Our ref: KT/2024/131869/01
20035862
Your ref: TR020005
Date: 21 August 2024

Gatwick Airport Northern Runway Application Development Consent Order Environment Agency response - Deadline 9

Comments on any further information/submissions received by Deadline 8

Figure 4.5: Change in peak flow in River Mole culvert due to CPX FCA – 3.33% AEP (12 hours storm duration)

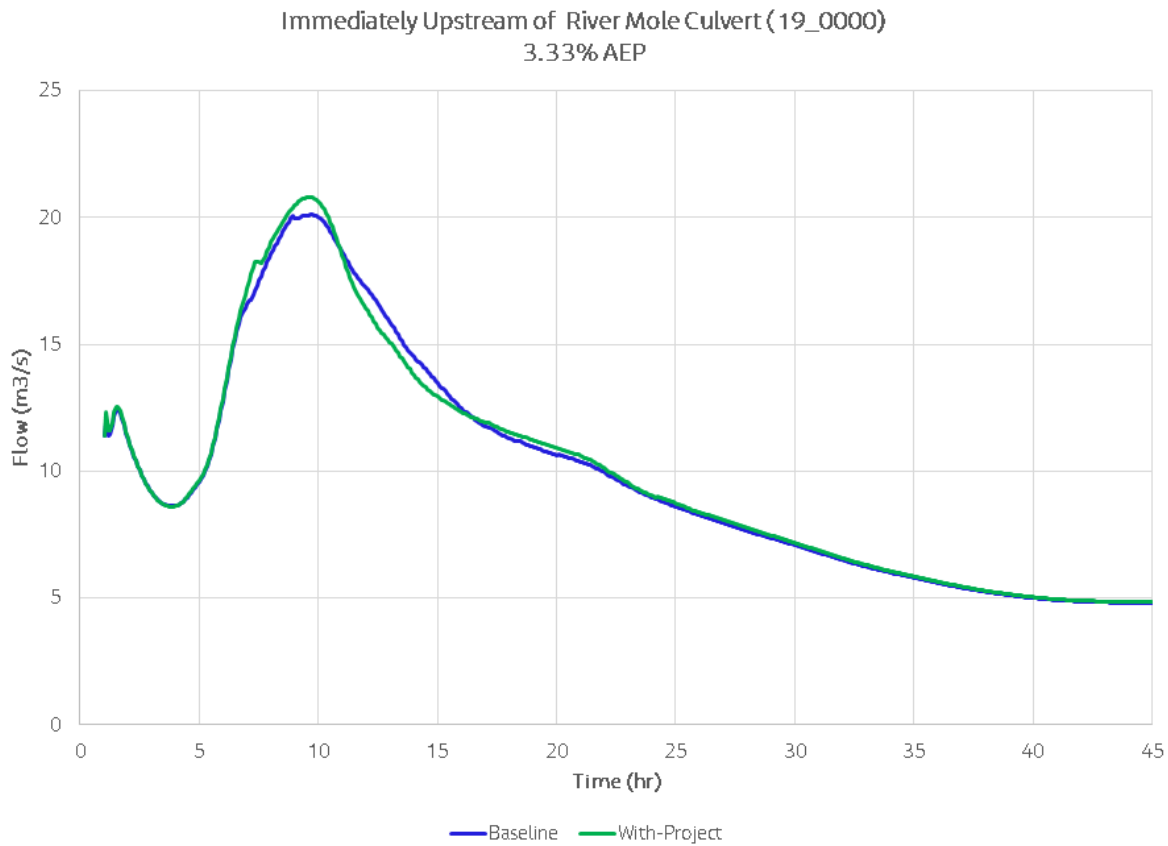
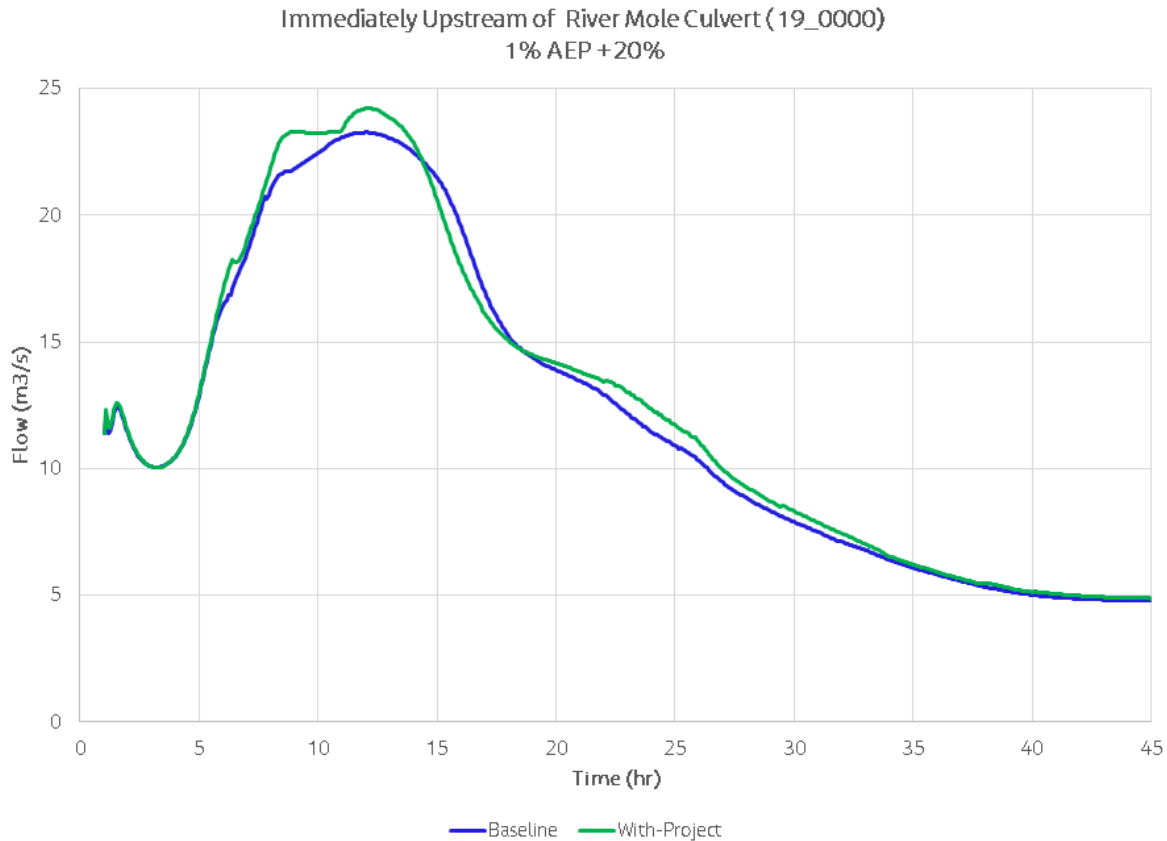
At Deadline 7, we asked for further detail on the increase in peak flows downstream of the flood compensation area (FCA) at Car Park X. The applicant suggests this is due to the culvert beneath the runway being able to flow more efficiently due to flows being attenuated by the Car Park X FCA, with this increase in flows being captured by the Museum Field FCA, thereby not leading to an overall increase in flows passing downstream of the Airport.

This does highlight the importance of the overall flood risk management strategy for the proposed development, clearly there would be an unacceptable increase in downstream flow if the Museum Field FCA was not delivered alongside the Car Park X FCA.

The sequencing of the construction of the FCAs is also important. The applicant should take this into consideration at the detailed design phase and take this onboard for construction sequencing. As this is important for the overall management of fluvial flood risk the Flood Compensation Delivery Plan (FCDP), as a living document, should also take this into account and be updated as necessary.

DRAWING NO. FIGURE 2.1	REVISION For FCDP Technical Note
	DRAWN BY MC	PM / CHECKED BY MS

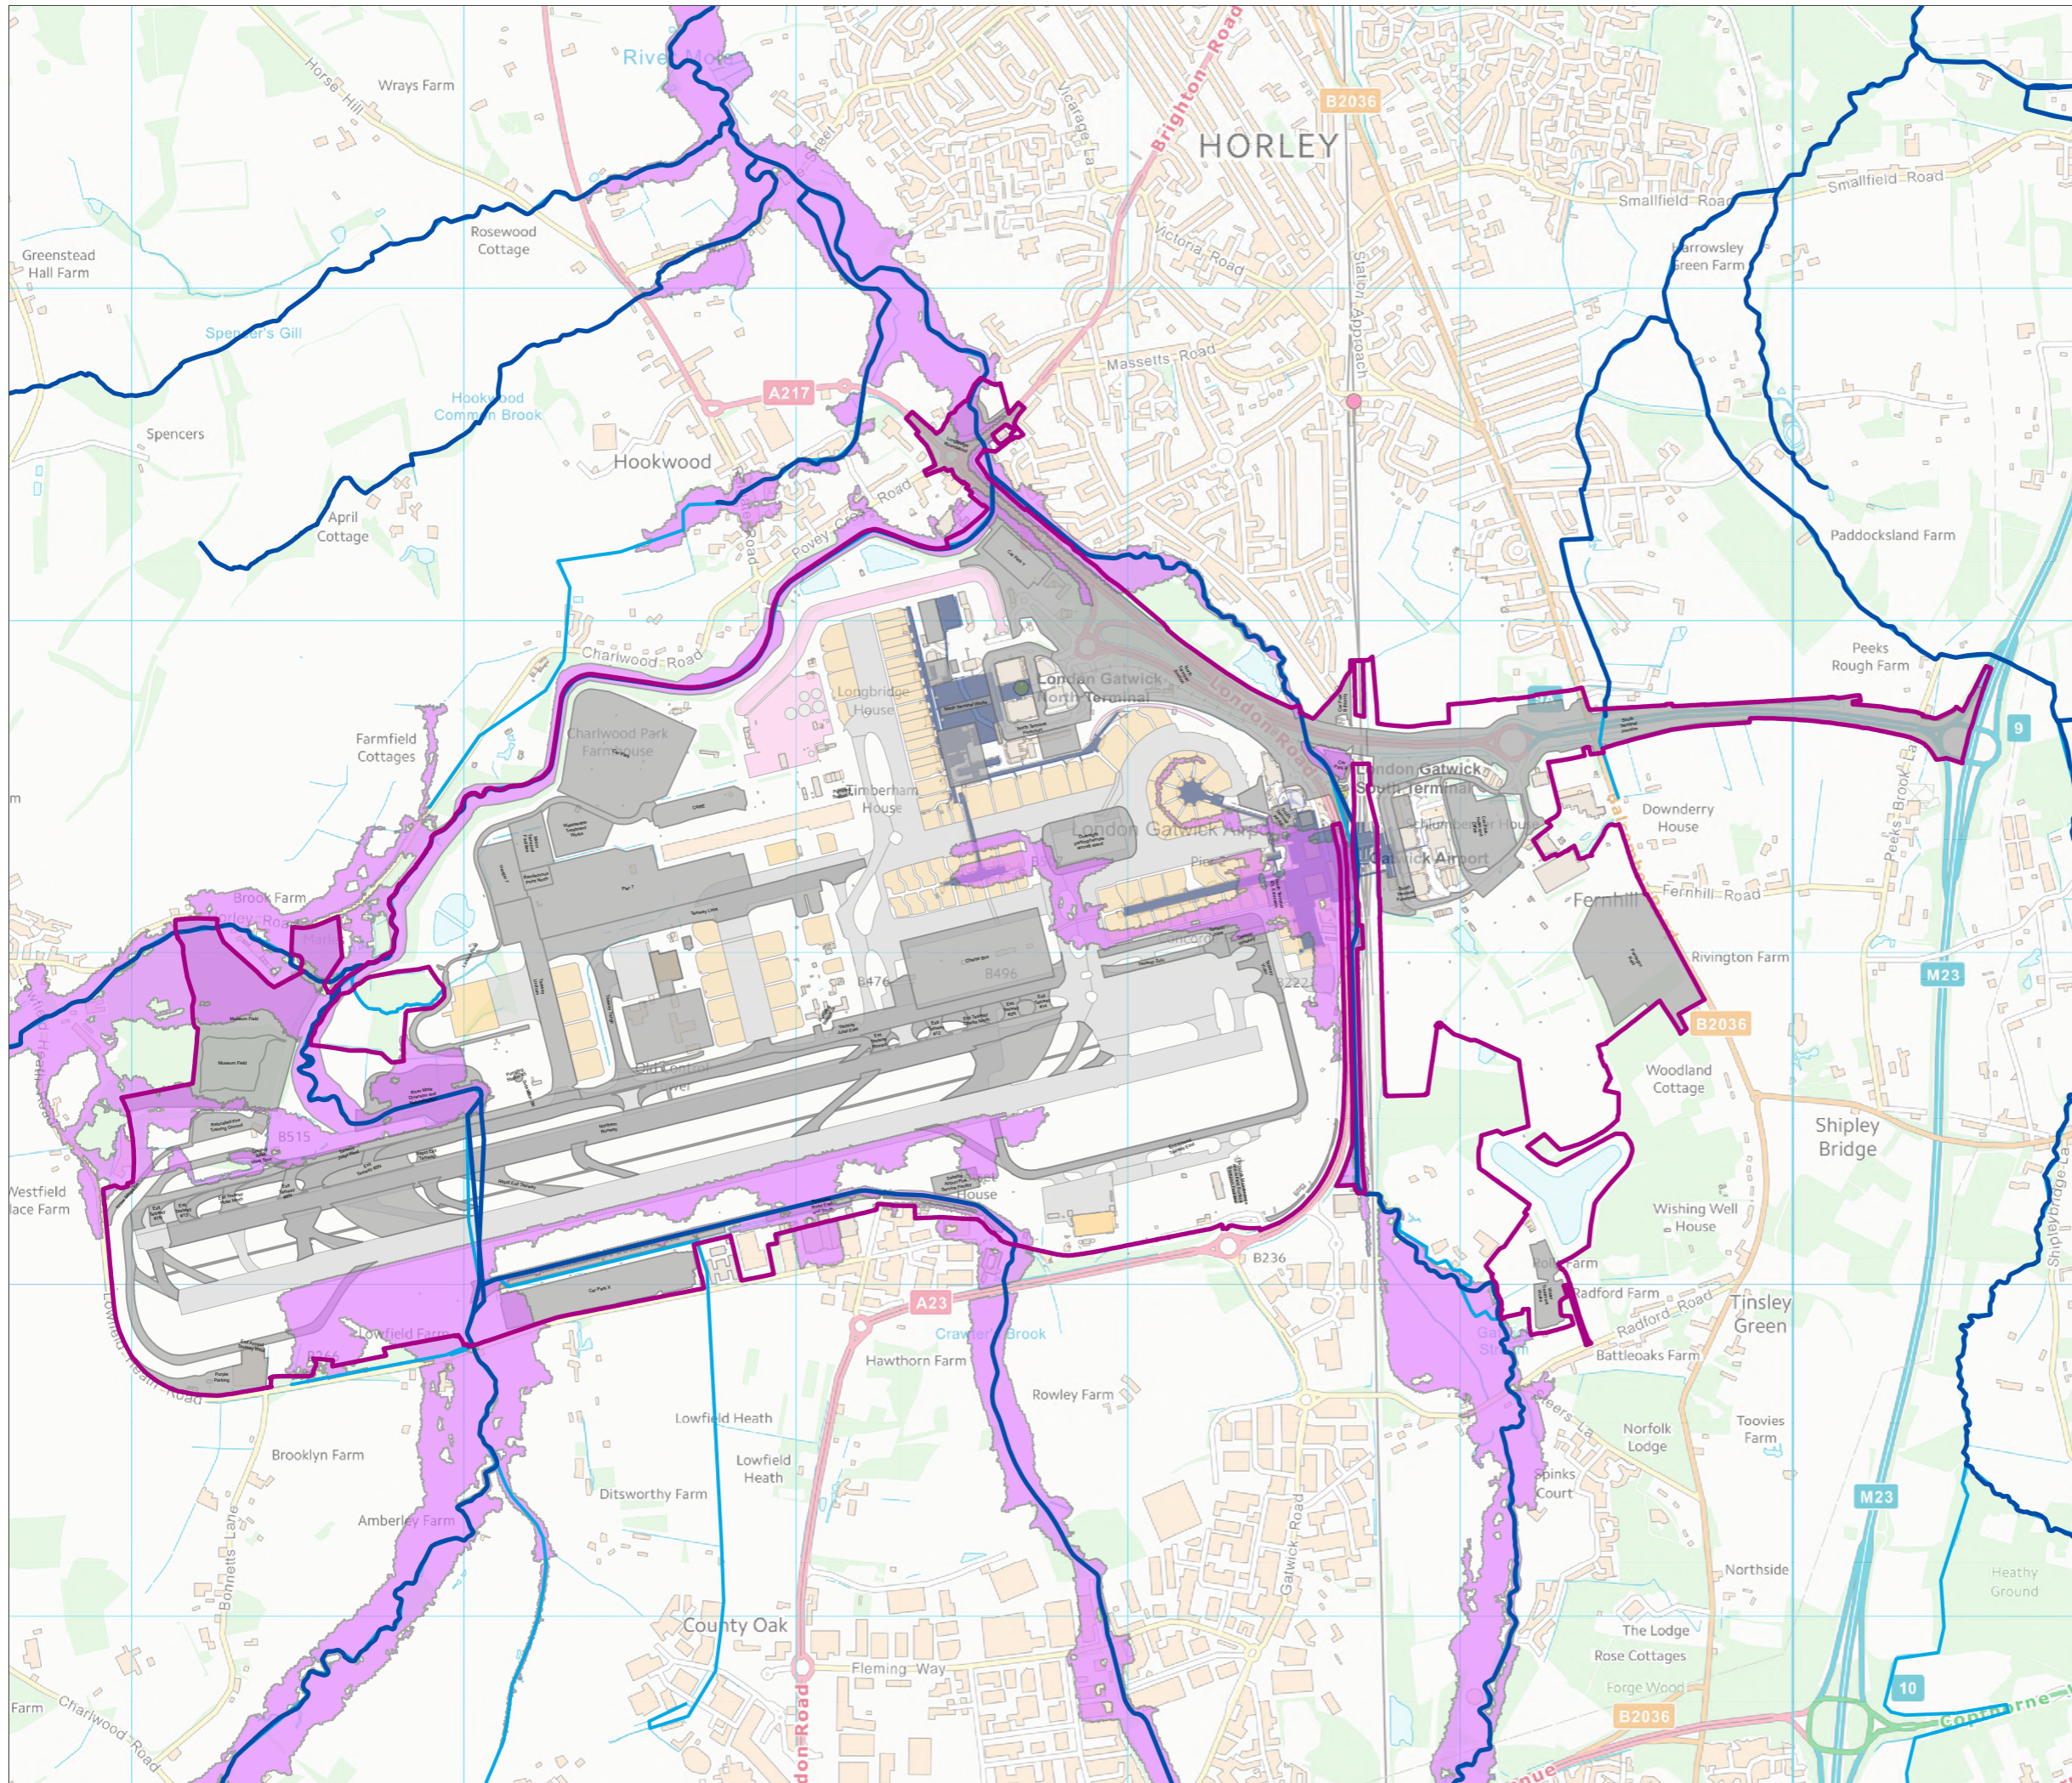
The addition of colour coding to Table 5.1 is helpful to better understand the impact of each of the Work Nos on flood risk, and actions to be taken to mitigate against this risk. The addition of the map within Version 2.0 of the FCDP also aids with this understanding and offers a visual reference to the location of the various Work Nos being discussed.
